**From:** Brenda Larsen  
**Sent:** Wednesday, February 22, 2012 9:42 AM  
**To:** Jeff Watson  
**Subject:** BL-11-00029 Leonard

Re: Leonard (BL-11-00029)

After conducting a review of the above named project, I have the following comments:

PROPOSED - Adjust Boundary to Creek

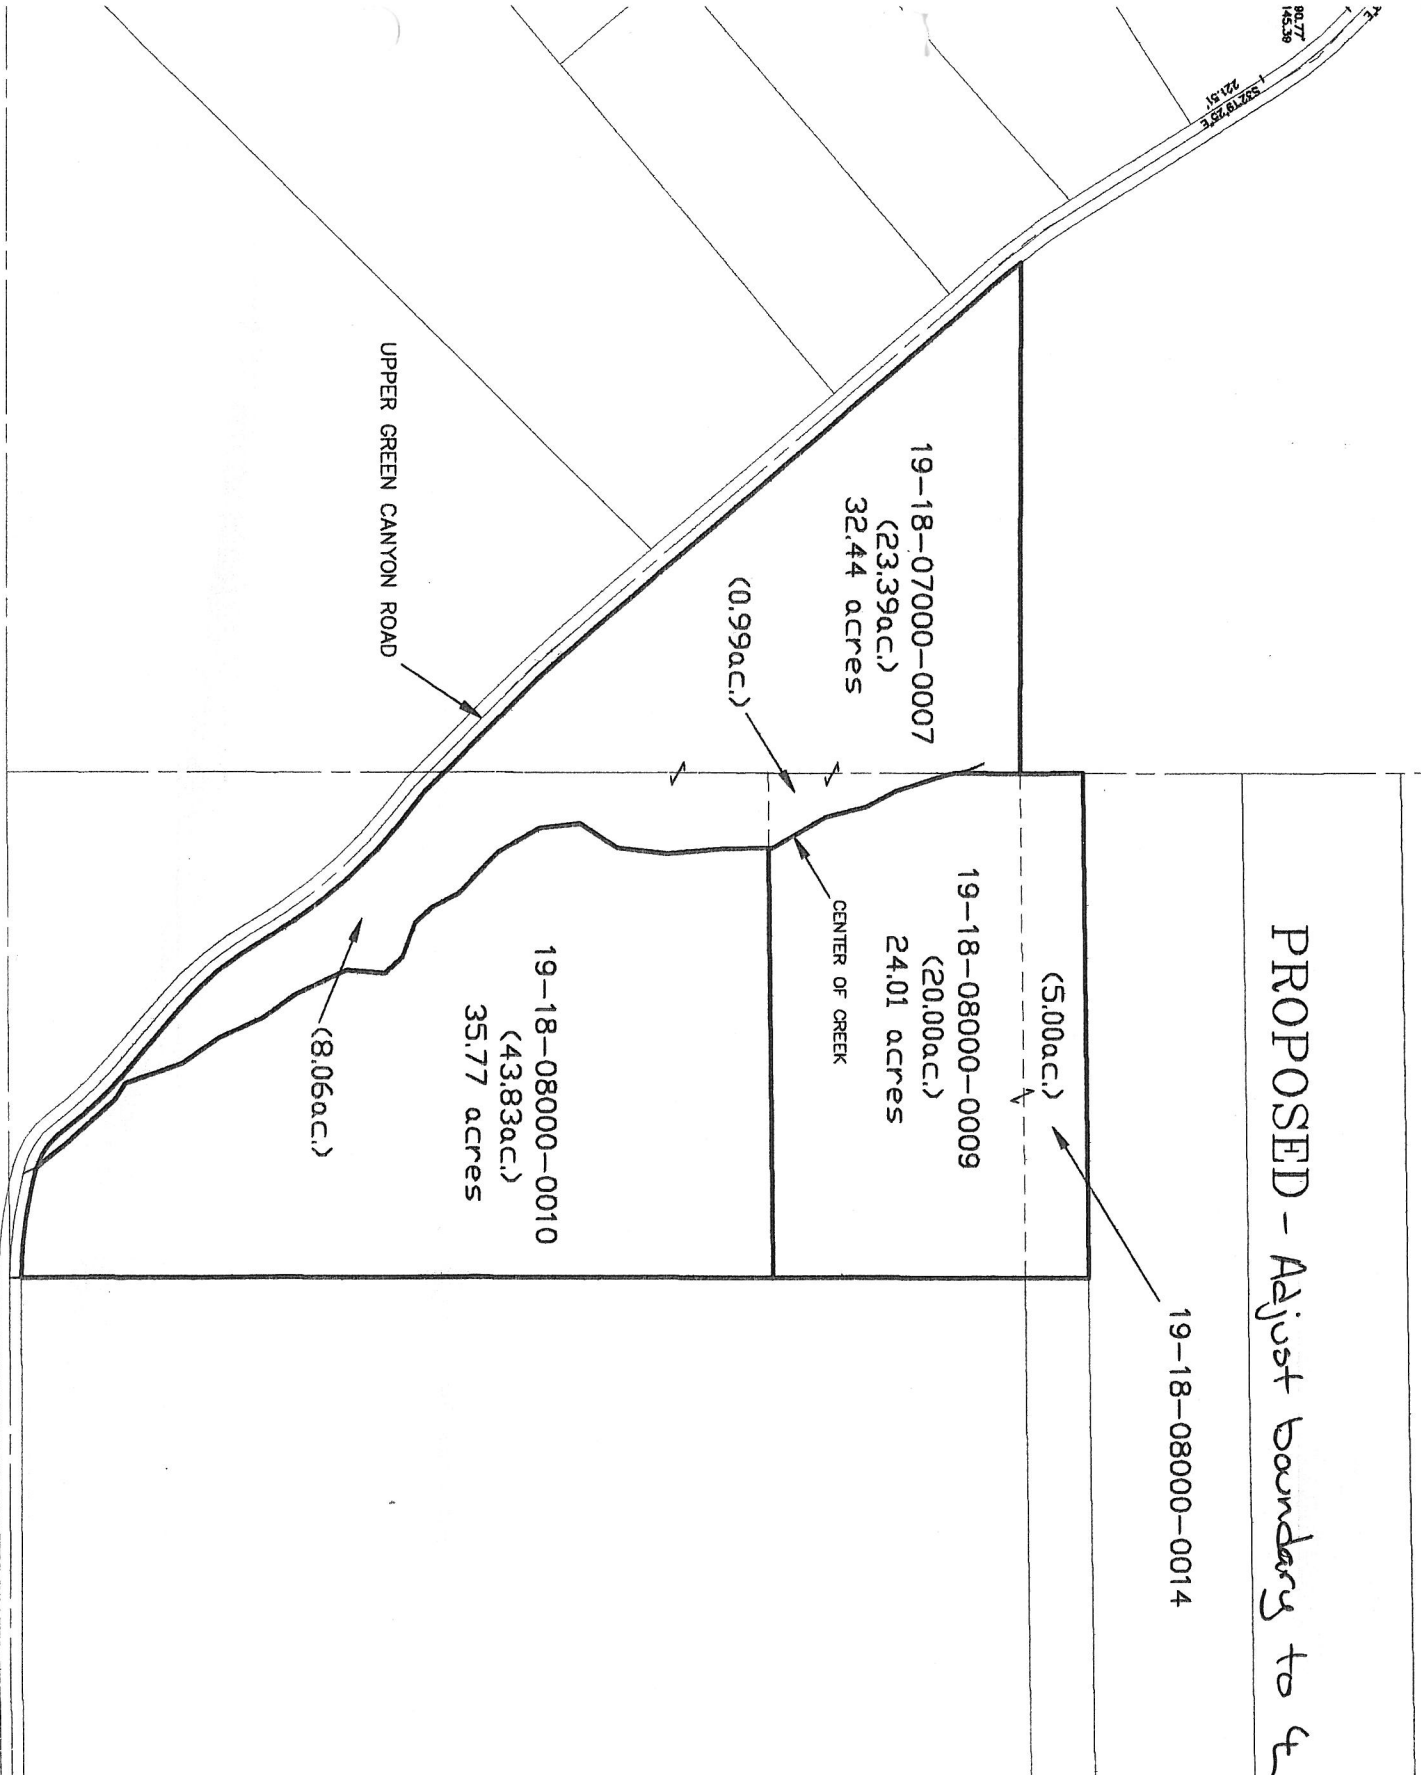
- Ensure that boundary line adjustments do not infringe upon existing structures, to include propane tanks, etc.
- Any driveway greater than 150' in length shall have an all weather surface of 16' in width.
- All future development must comply with the International Fire Code.
